DELEGATED HOUSEHOLDER DECISION

Item No.	Report of the Head of Development Management and Building Control	
Address:	DOWNSIDE KEWFERRY DRIVE NORTHWOOD	
Development:	Erection of part single storey, part double storey side and rear extensions following demolition of existing detached garage, conversion of roof space into habitable use to include 1 x rear dormer, 2 x rear facing roof lights, and 2 x front facing dormer windows, and amendments to fenestration and new porch structure together with associated excavation to create a rear outdoor patio.	
LBH Ref Nos:	2025/APP/2024/2399	
Drawing Nos:	24199-24-03 6193-PL001 - Rev F 6193- PL010 - Rev F 6193- PL011 - Rev F Site Location Plan 24199-24-02 6193PL012 - Long section	
Date Plans received:	05-09-24	Date(s) of Amendments(s):
Date Application valid	30-09-24

Drawn By	AS	Date	30.07.2024
Checked By		Date	04.09.2024
Approved By		Scale	1:100 @ A1
Drawing No.	6193PL010	Rev.	E

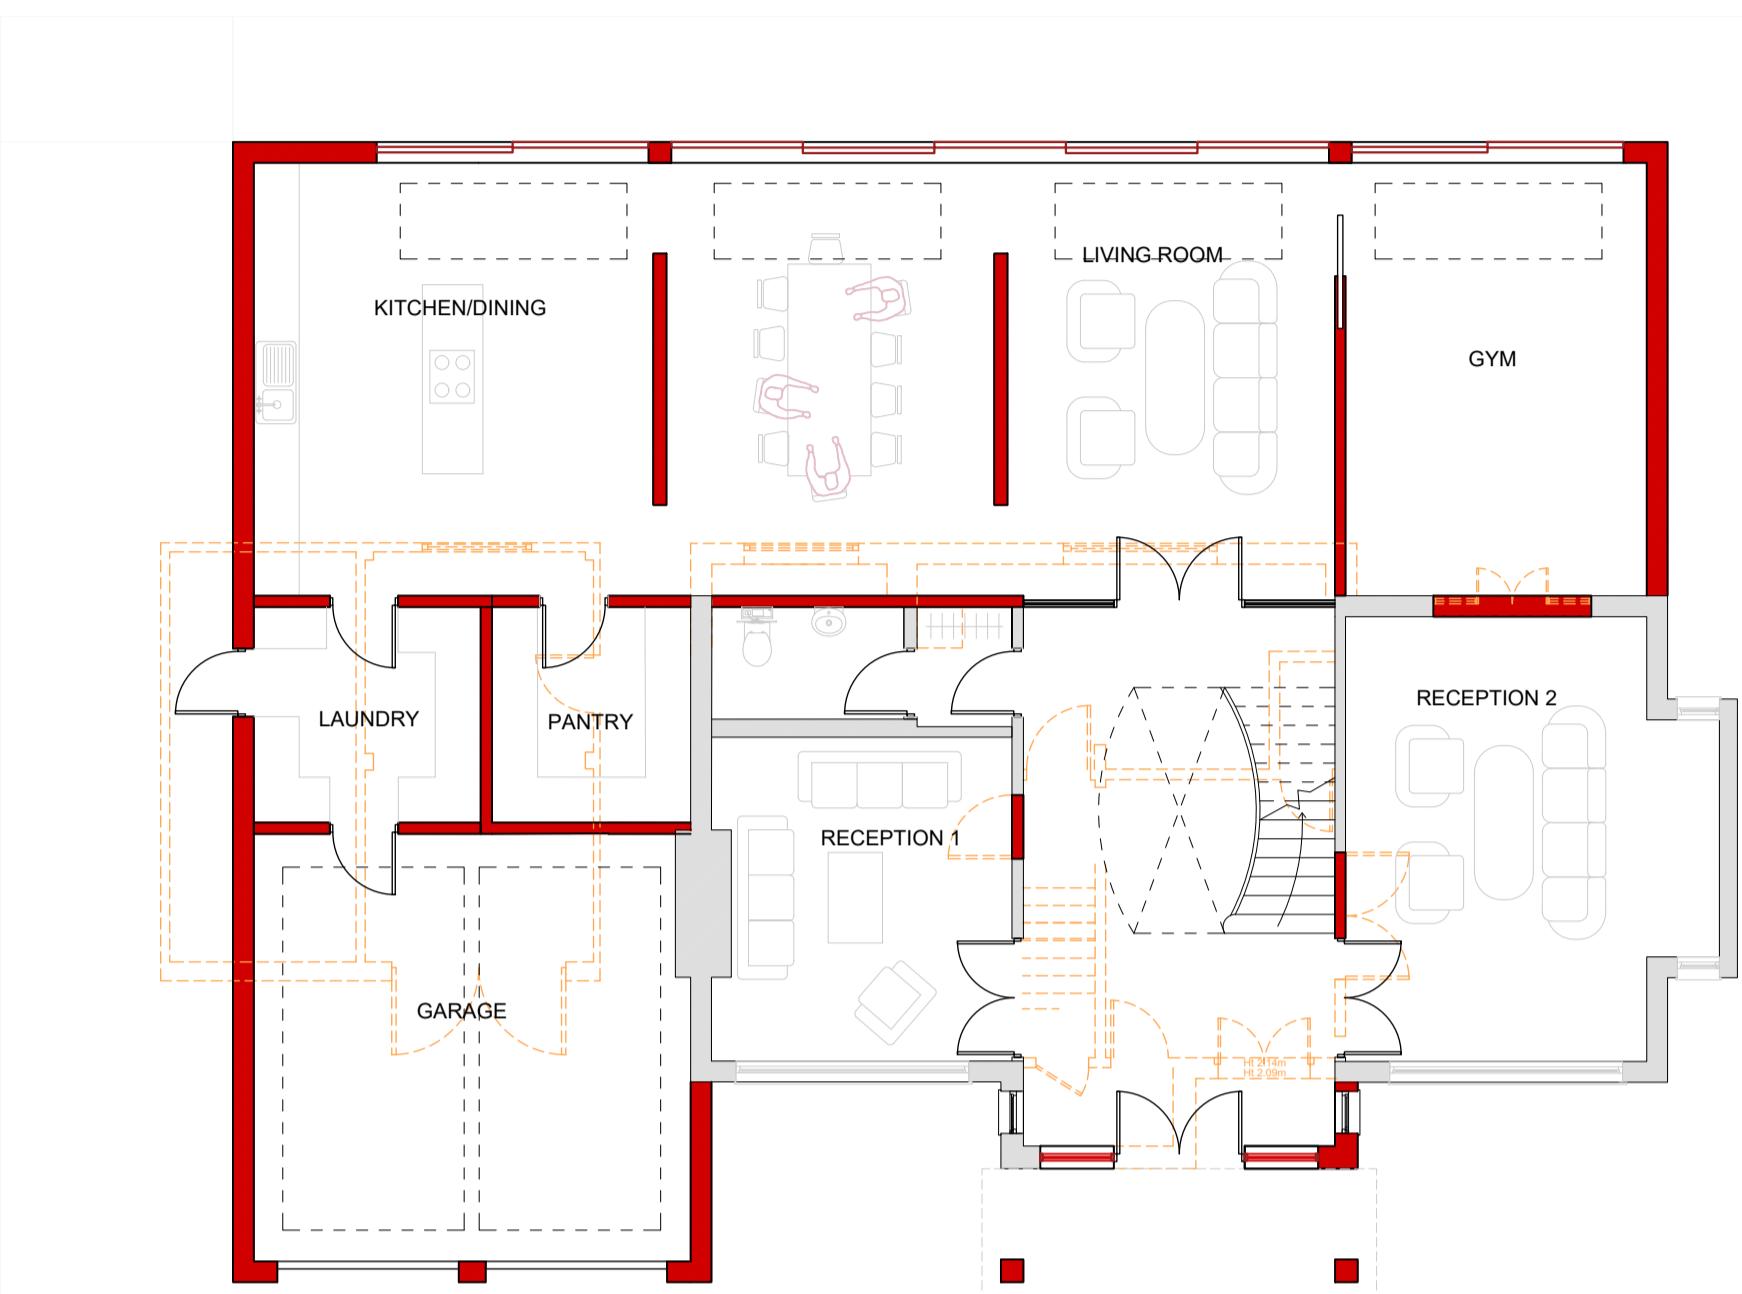
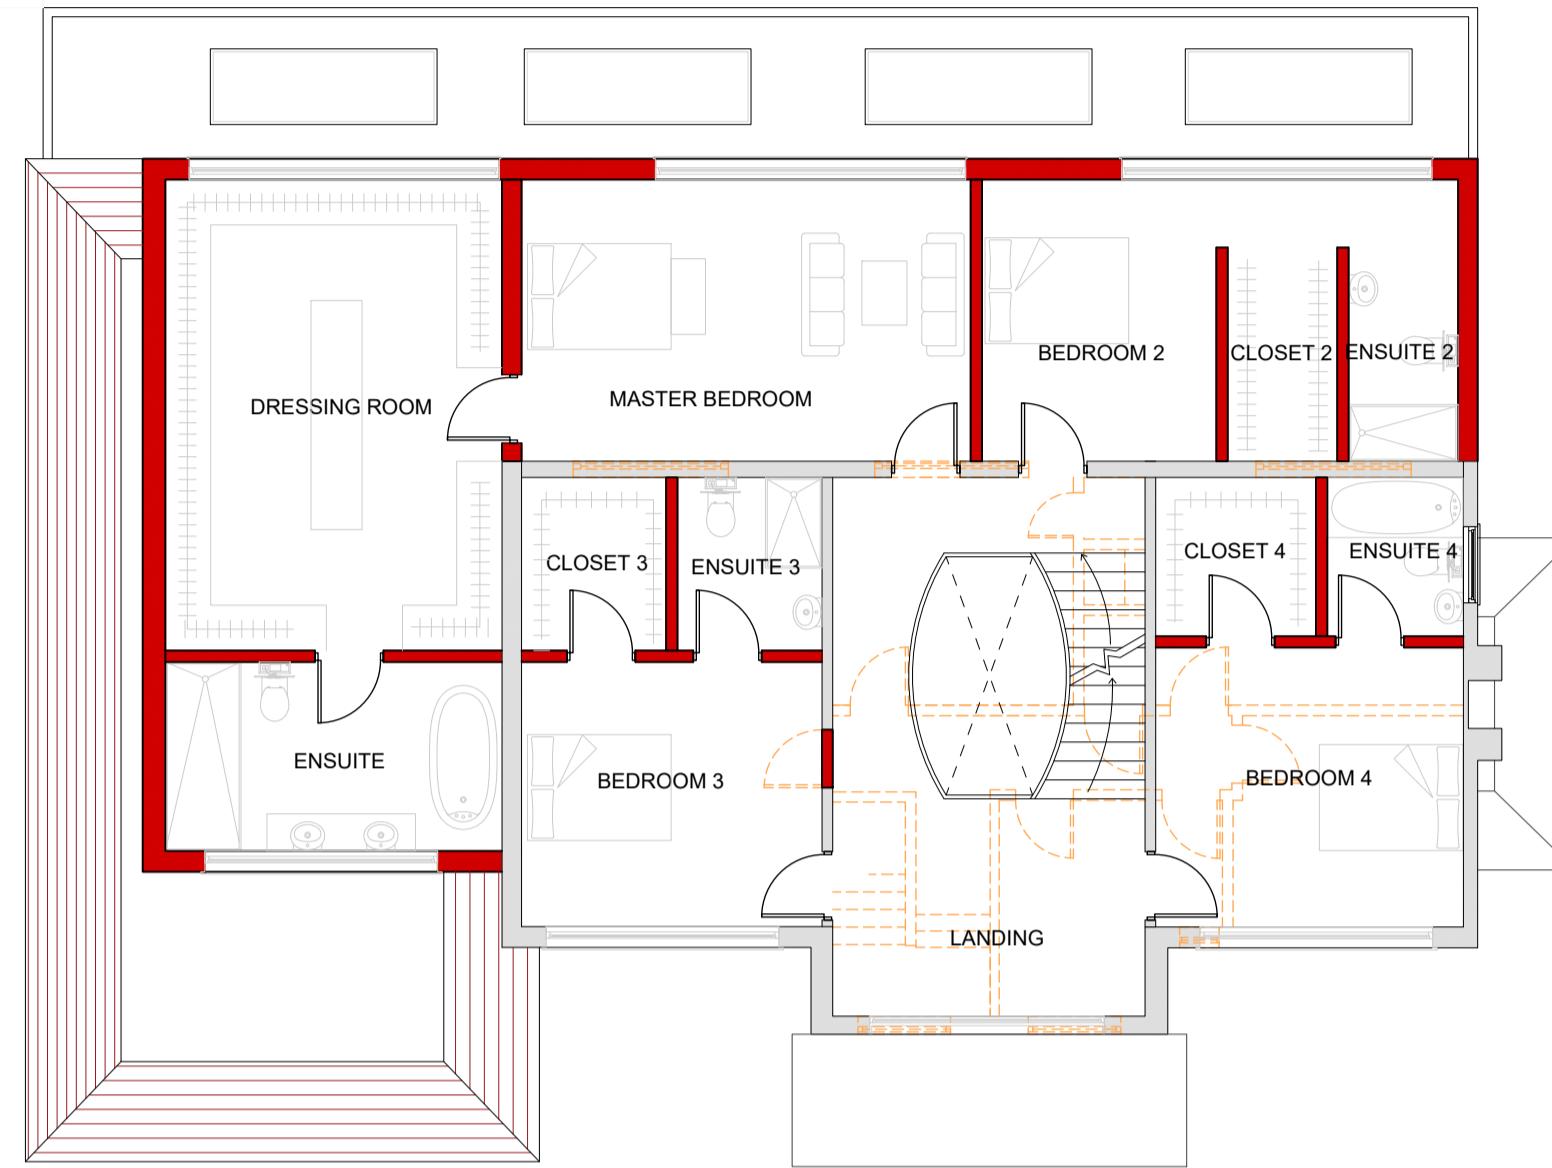
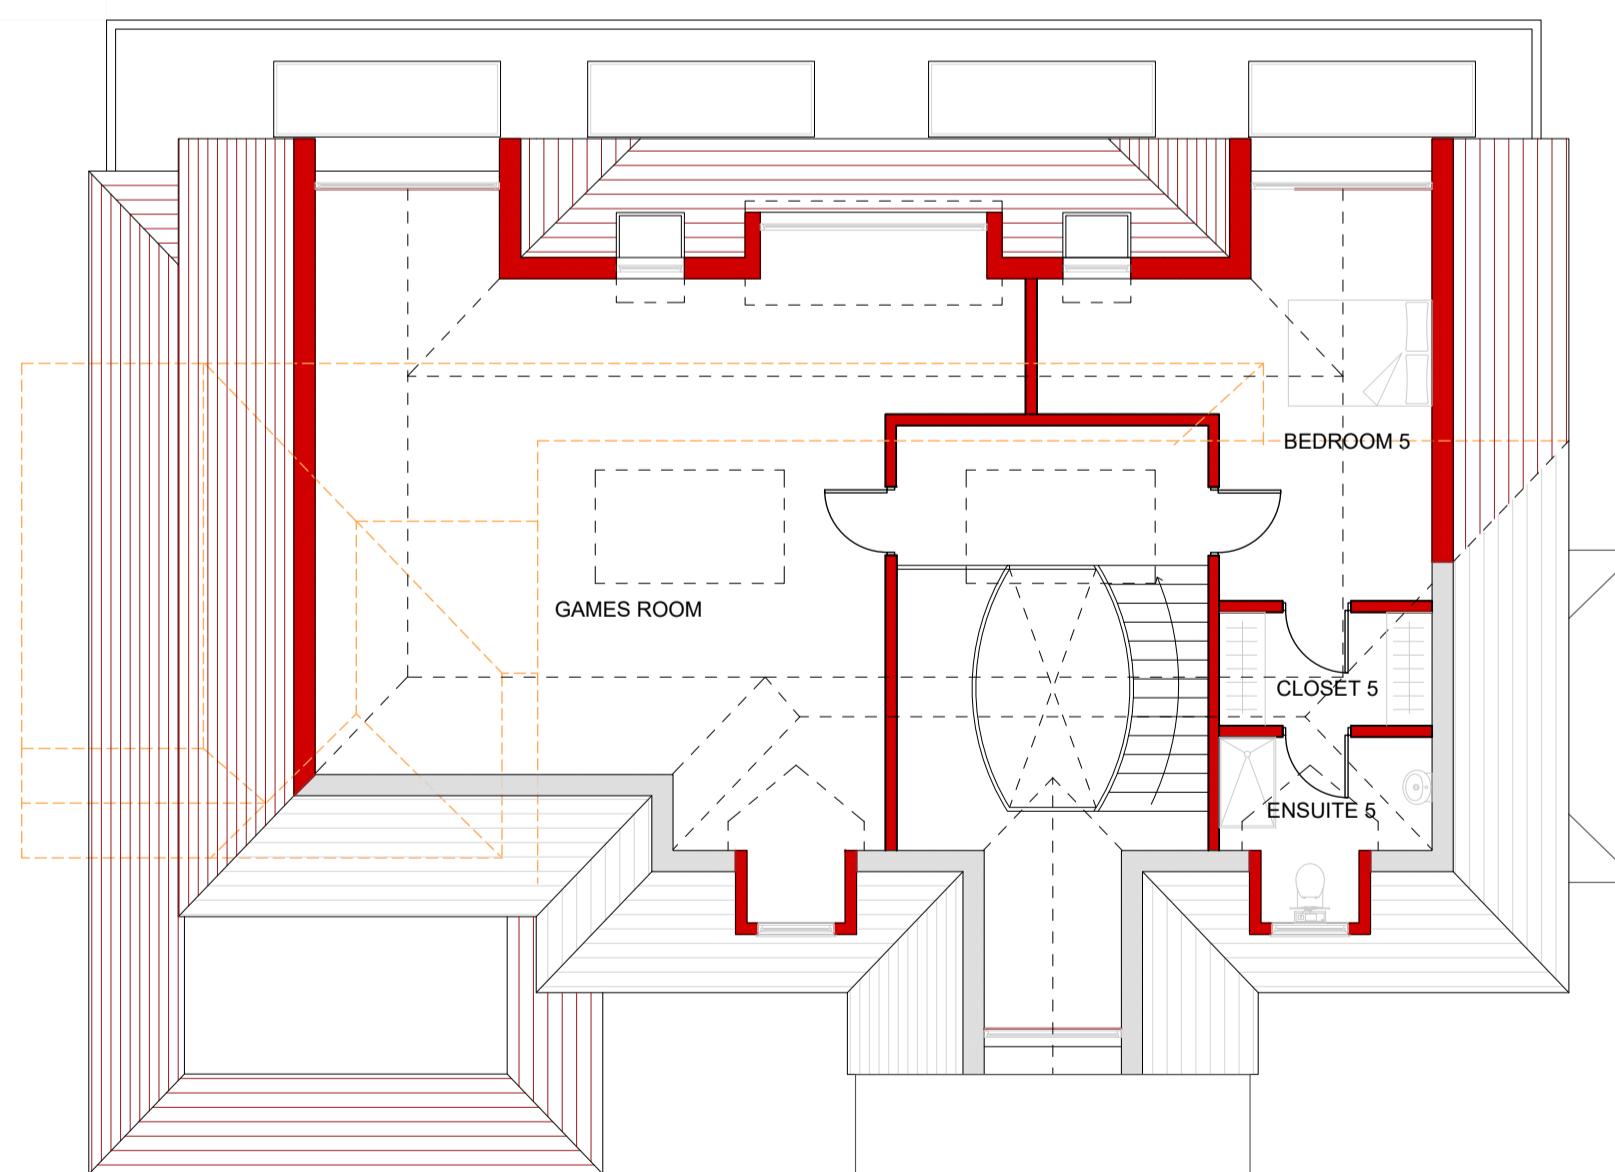
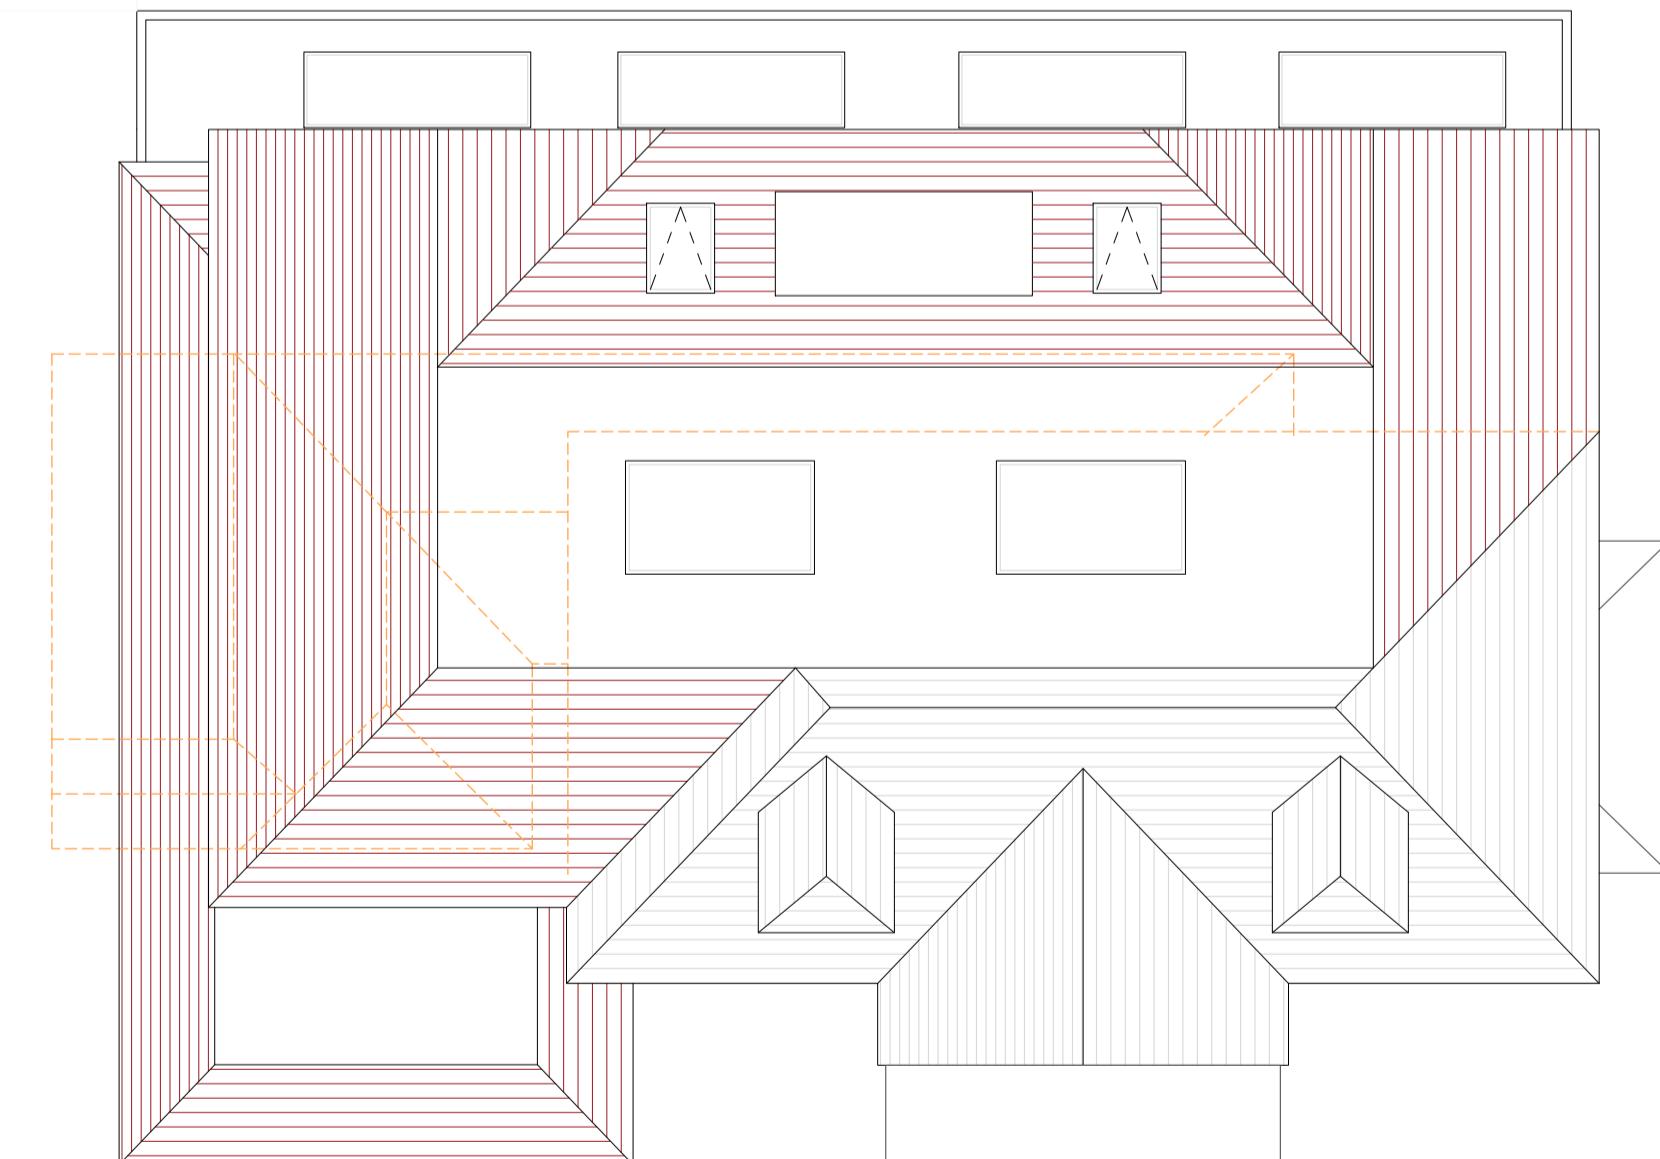
- 1.Redesign of the exterior of the building.
- 2.Set back of the side extension from the front elevation by a 1m
